RE: **Winrock Road Town Center**
2100 Louisiana Blvd NE
Drainage Master Plan- Drainage Implementation Plan
Engineer's Stamp Date: 4/29/19
Hydrology File: J19D058

Based on submittal received on 4/29/19, the Drainage Implementation Plan cannot be approved for Site Plan for Building Permit until the following are corrected:

STORM DRAIN AP-A 100 EXISTING CONDITIONS

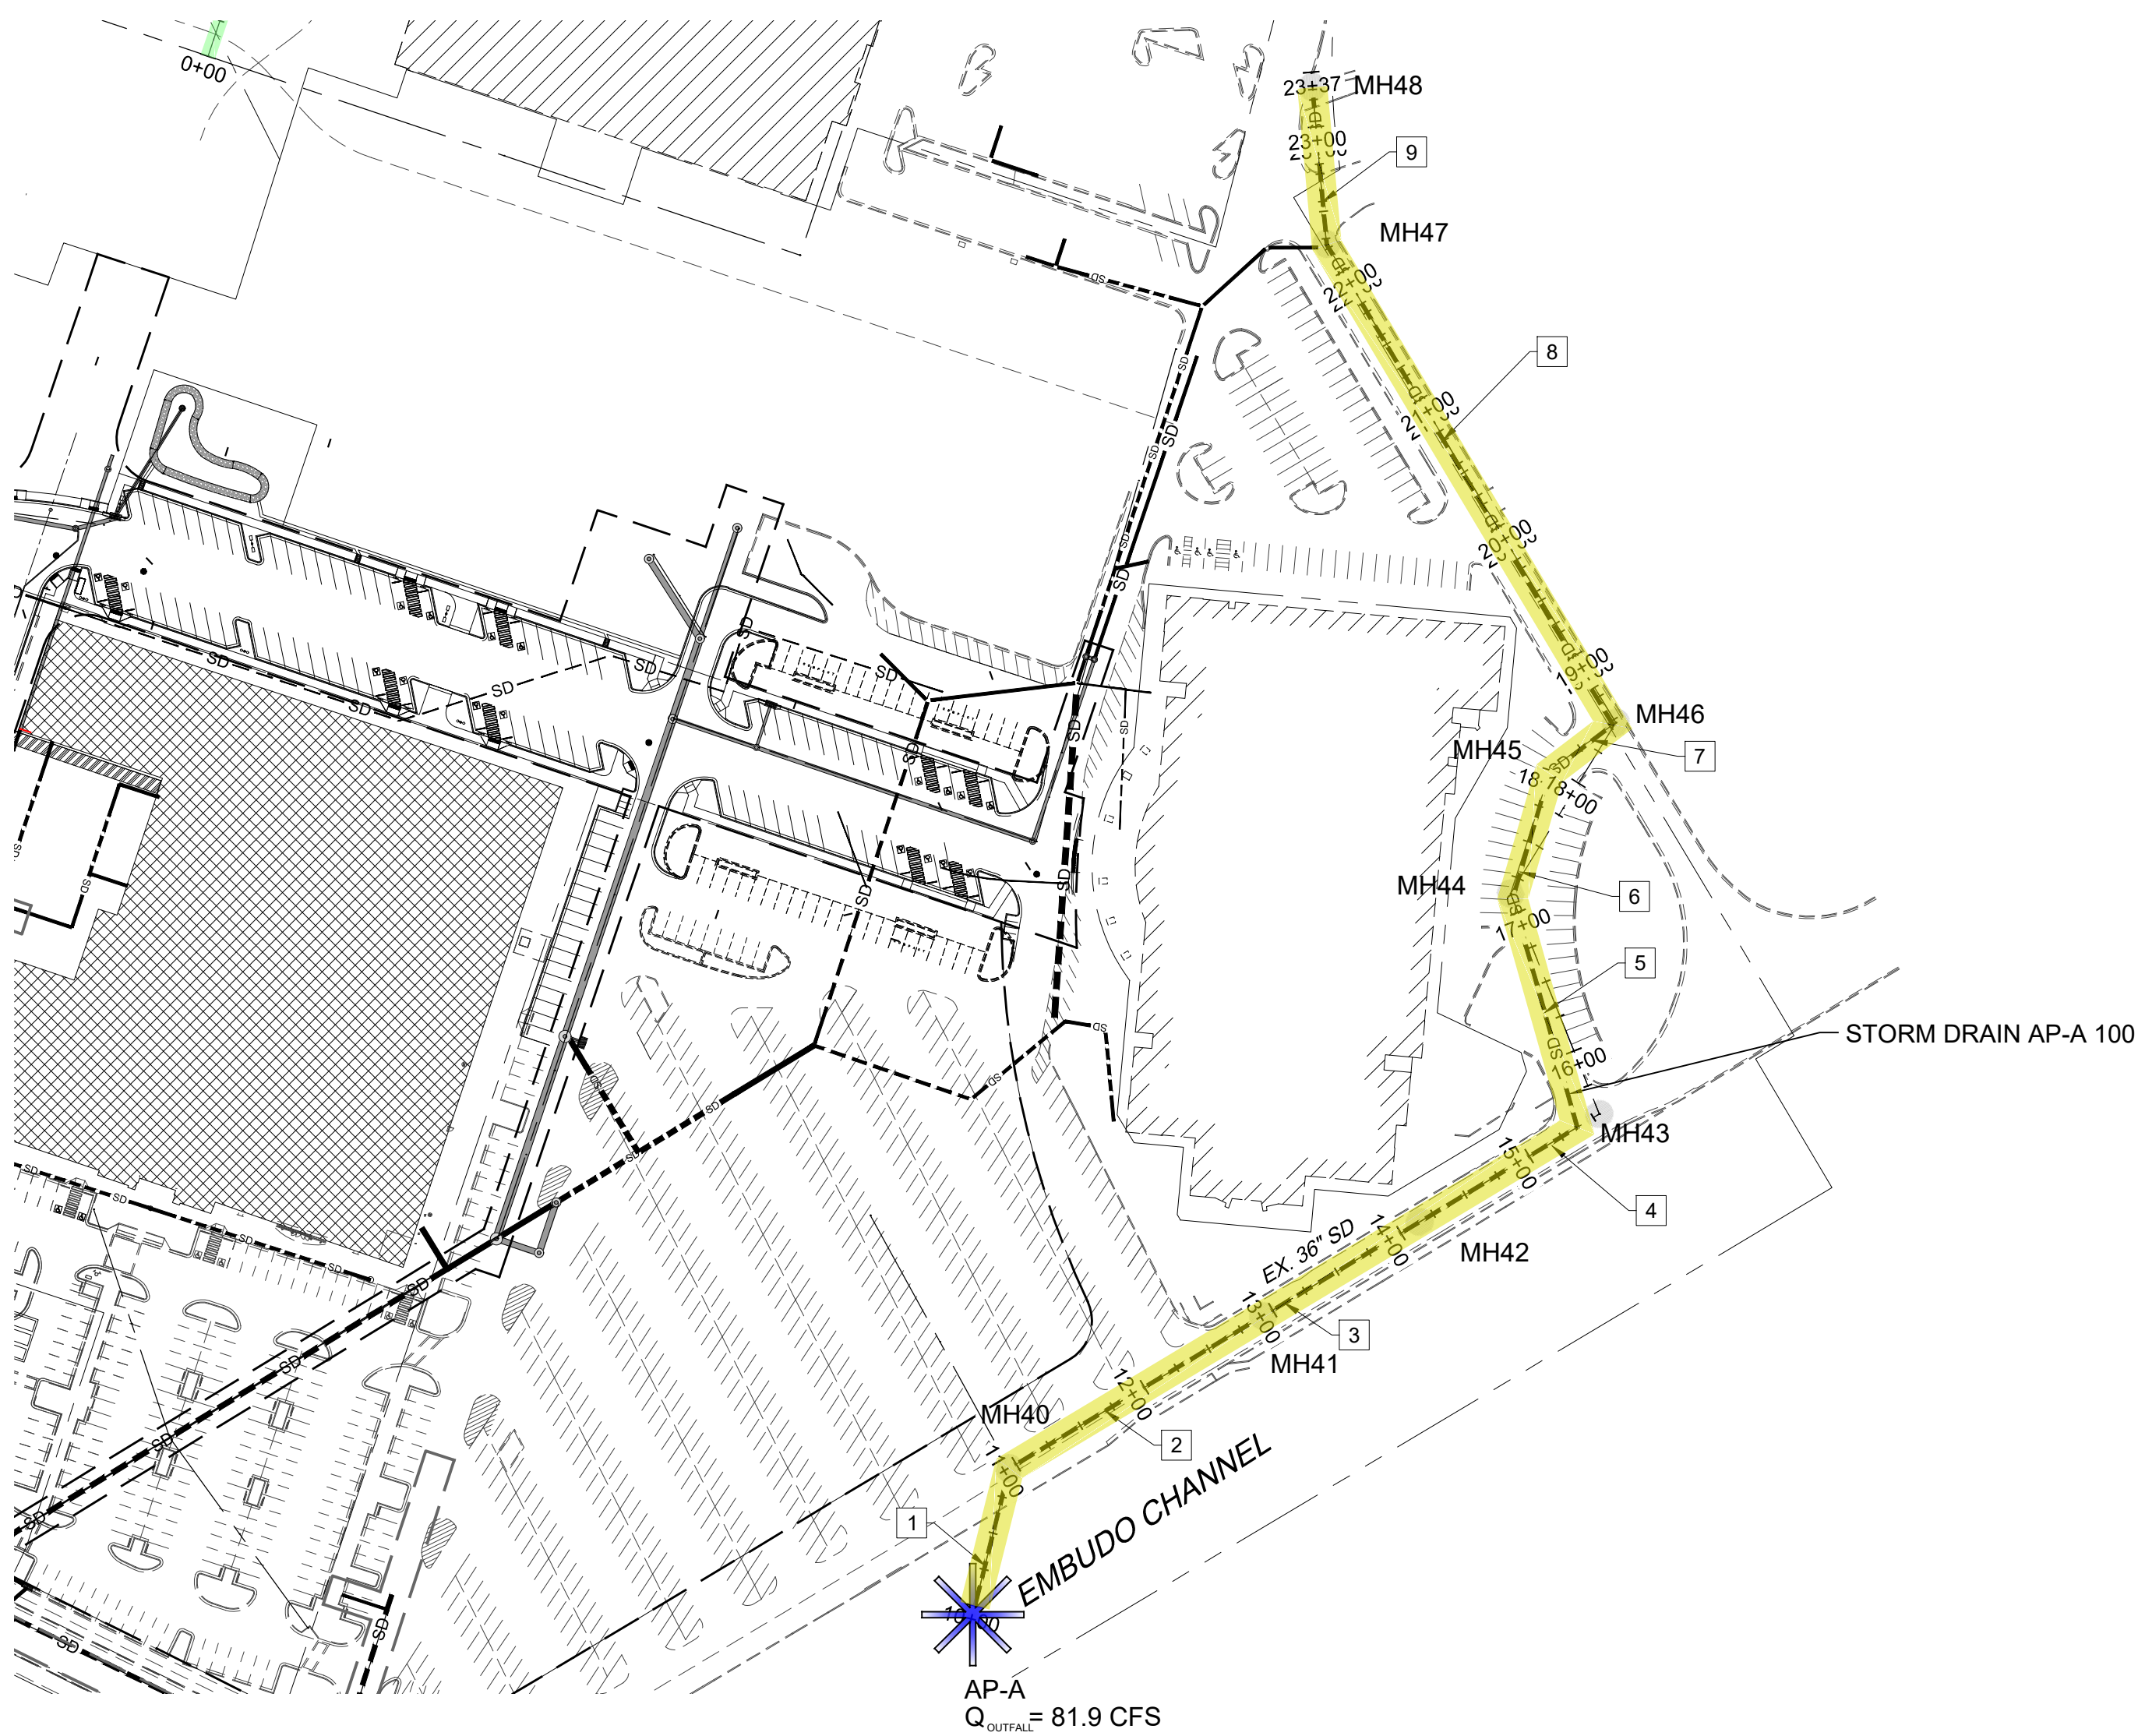
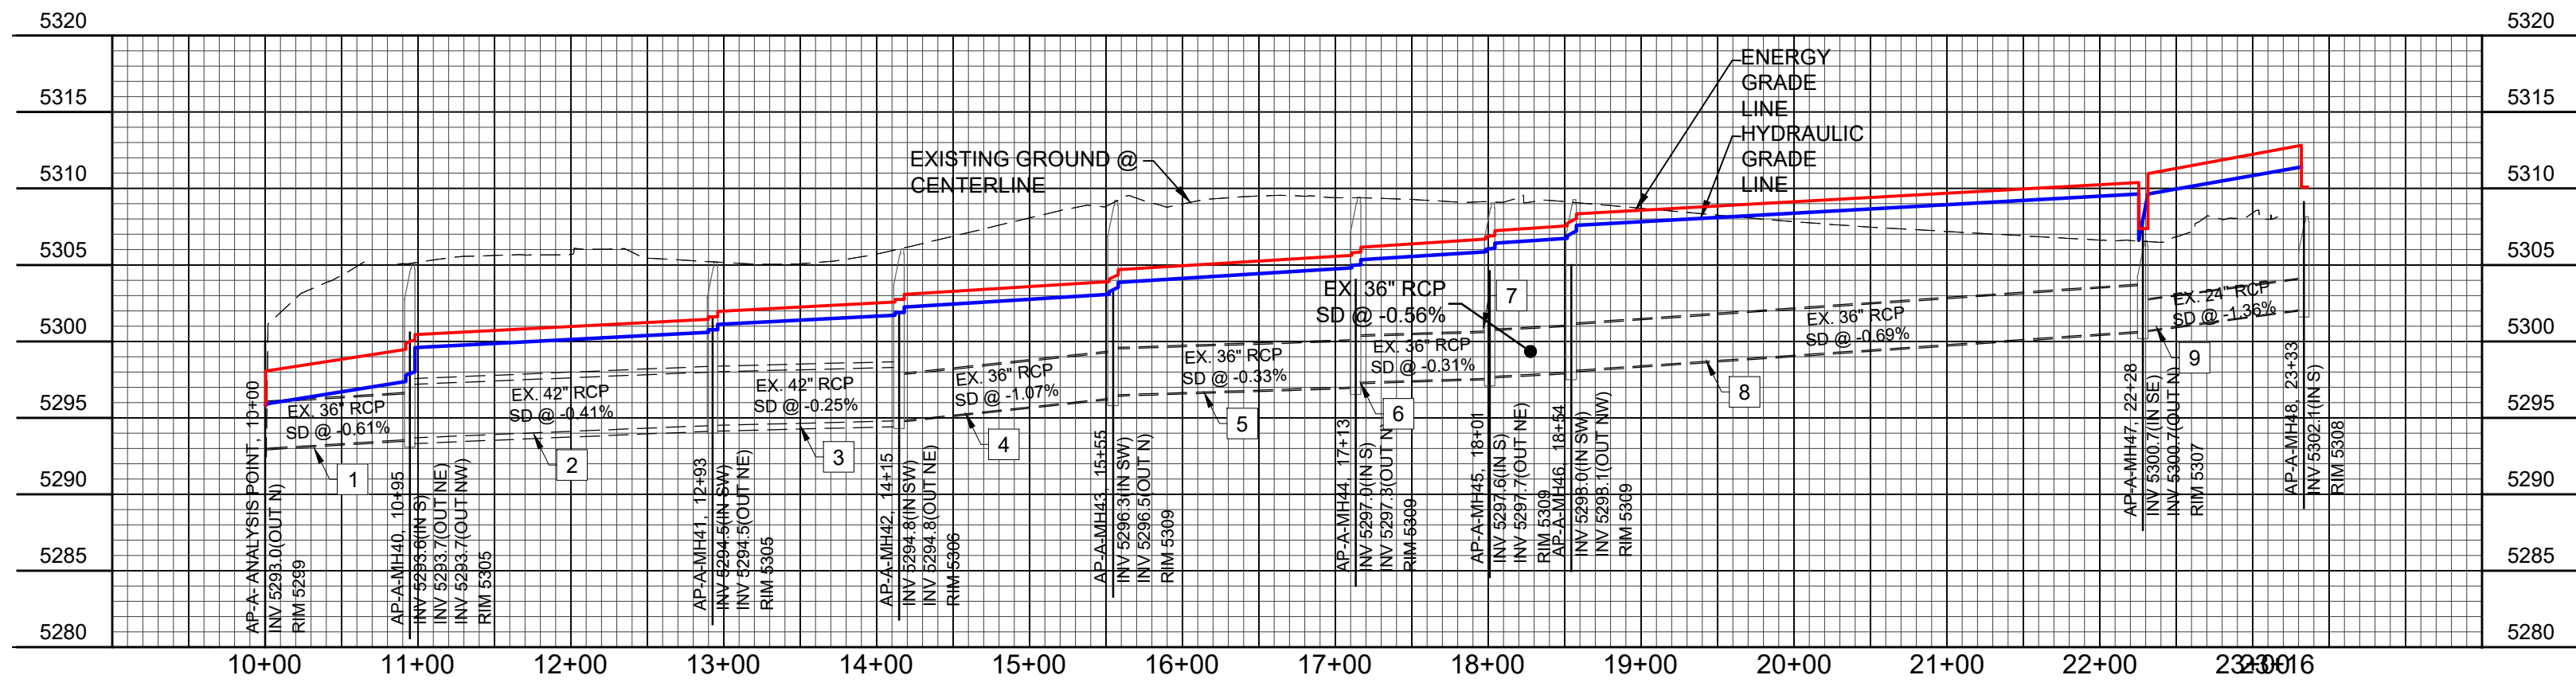
- c. Exhibit 4, the profile for AP-B 400 is cropped.
 - d. Storm drain profiles/model for AP-A are missing
4. In the output tables, relabel the "Flow" column as "Allowable Flow" or similar. Or remove the "Capacity" column. It needs to be clear that the allowable flow to each pipe is established by the hydraulic model (not Manning's).

City Project No.	4553.90	Zone Map No.	J-19-Z	Sheet	Of
				EXHIBIT 1

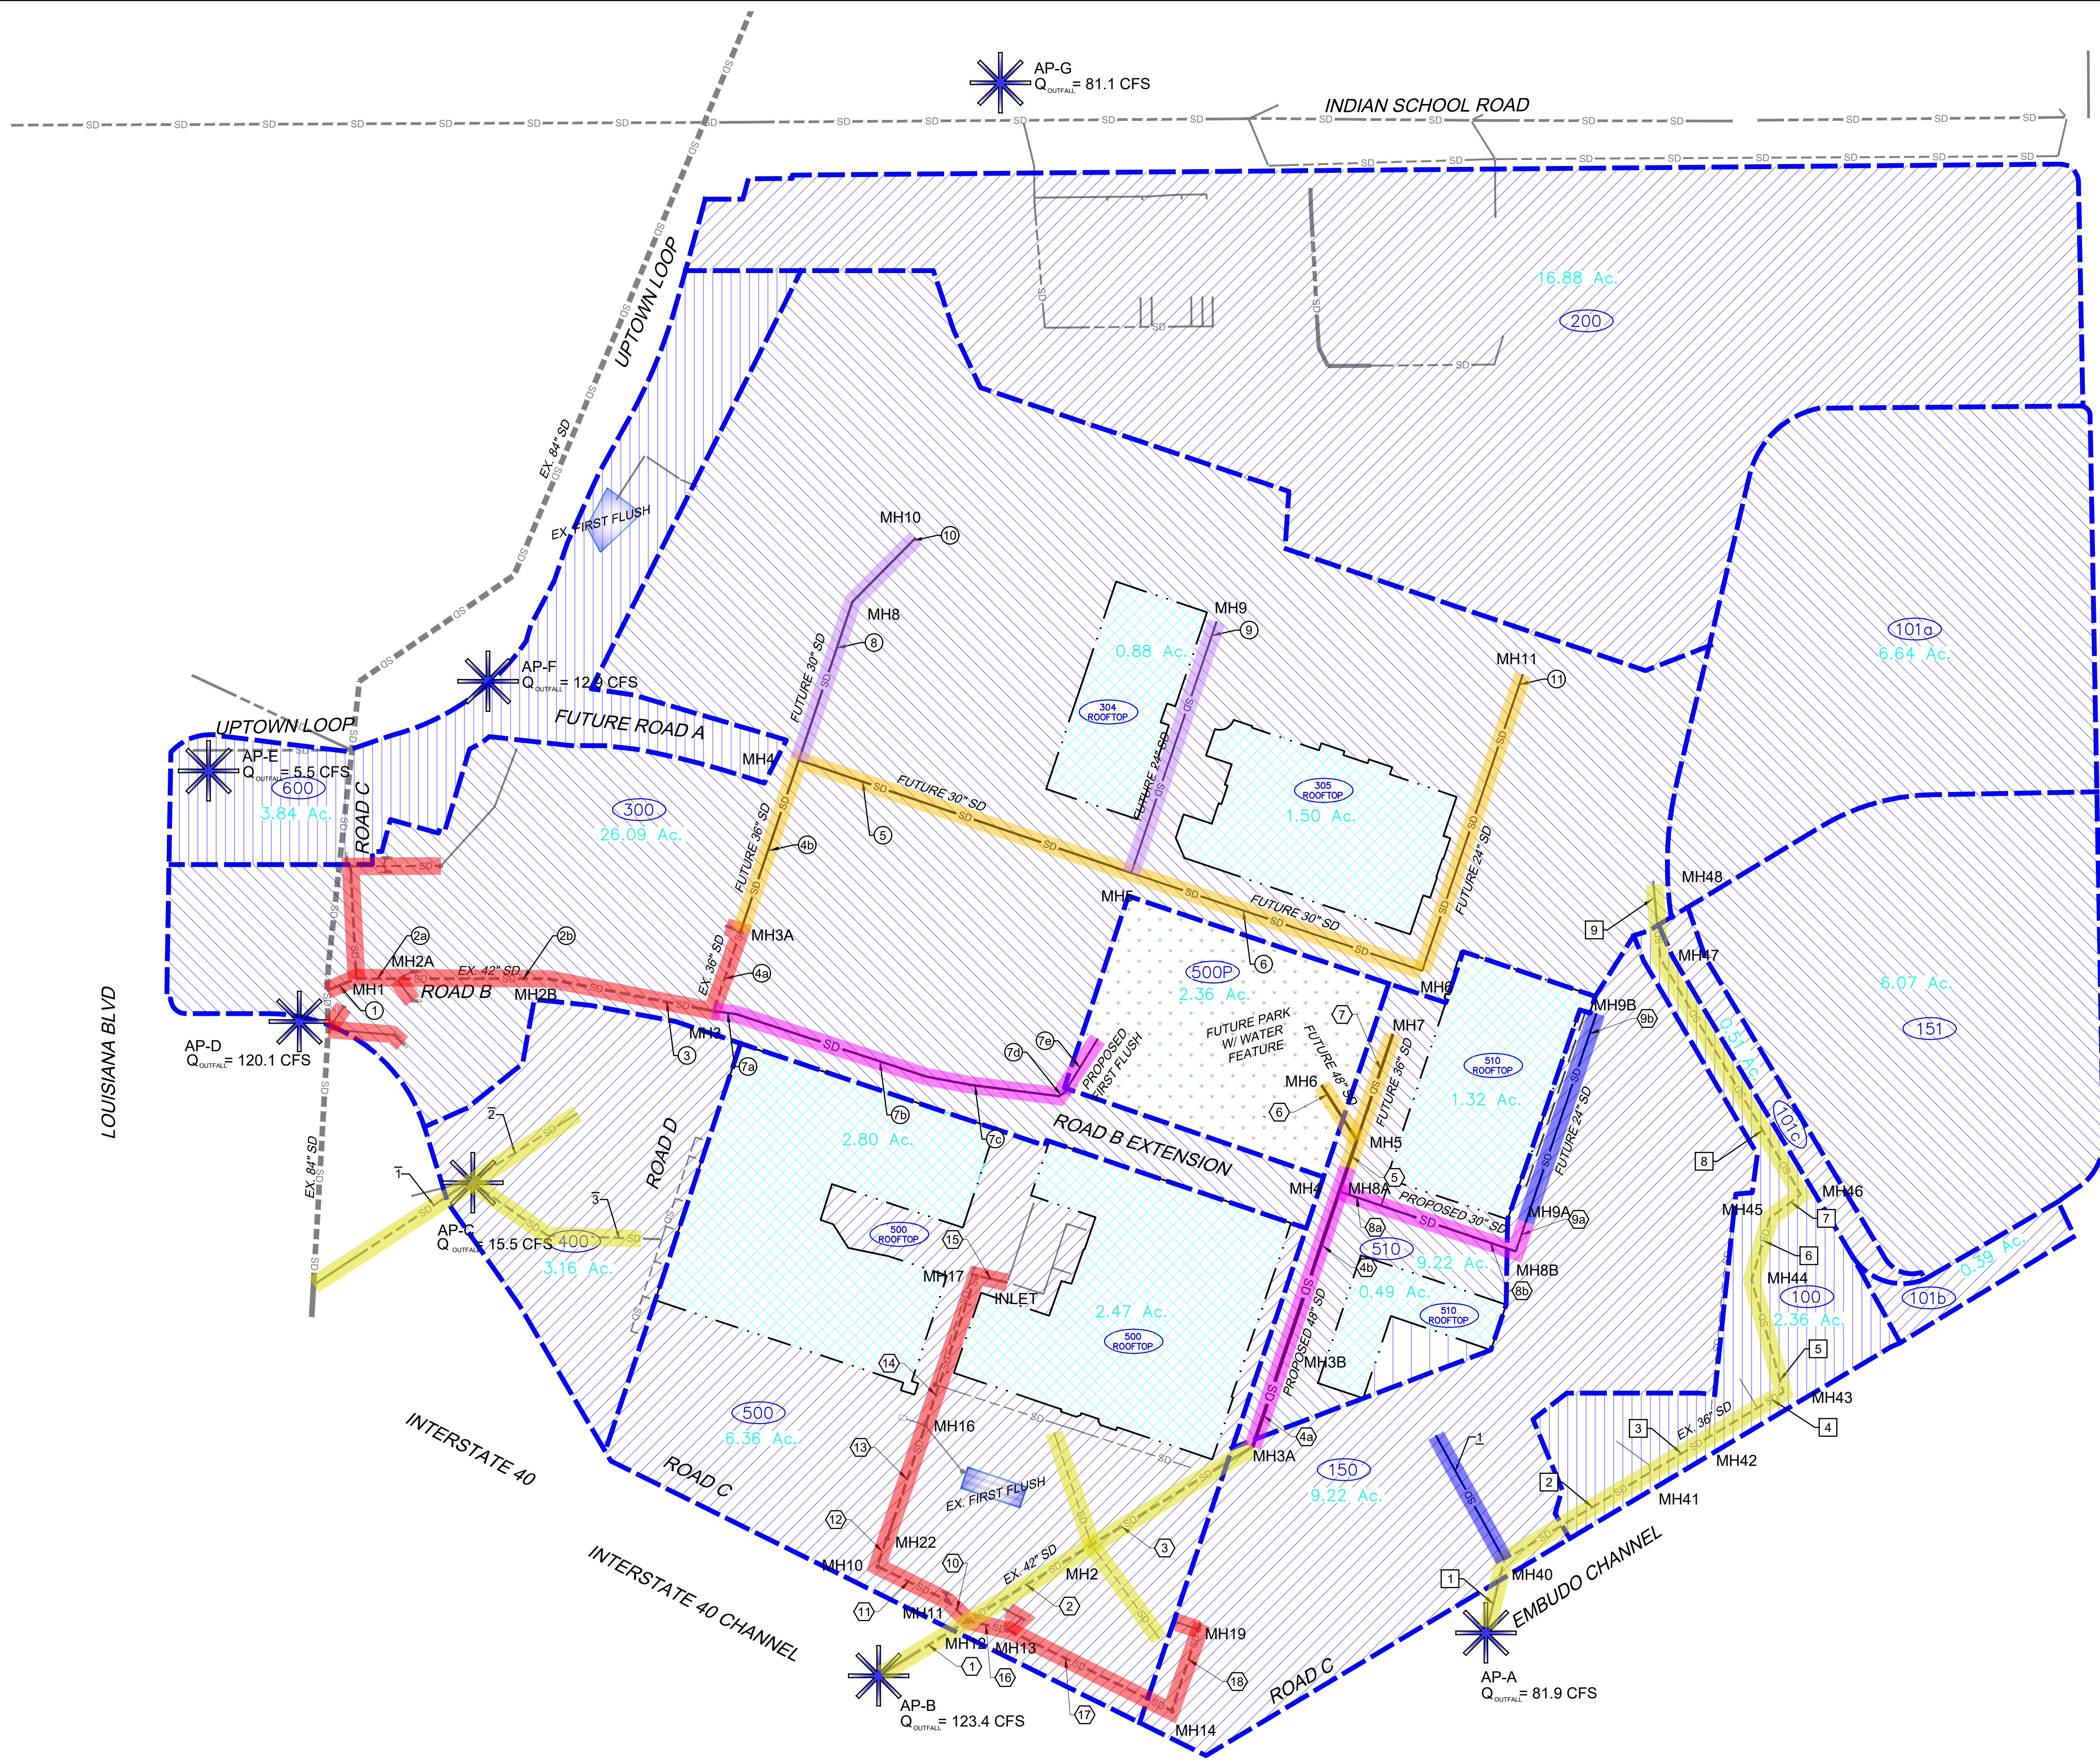
5. Include Exhibit 1 in the DRB Master Site Plan. Please check that the phases match the Architect's phases. The remaining exhibits (2-7) can remain in the DIP, so long as the master summary table is provided on Exhibit 1.
6. Site Hydrology needs to reference the 2015 DMP, as this DIP is accepting it as-is.
7. Only one paper copy of the submittal is required.
8. Prior to Work Order for each phase, a detailed drainage report will be required to detail many of the hydraulics shown in the DIP as well as address all grading and drainage criteria per the DPM, such as storm water quality and surface flow hydraulics.
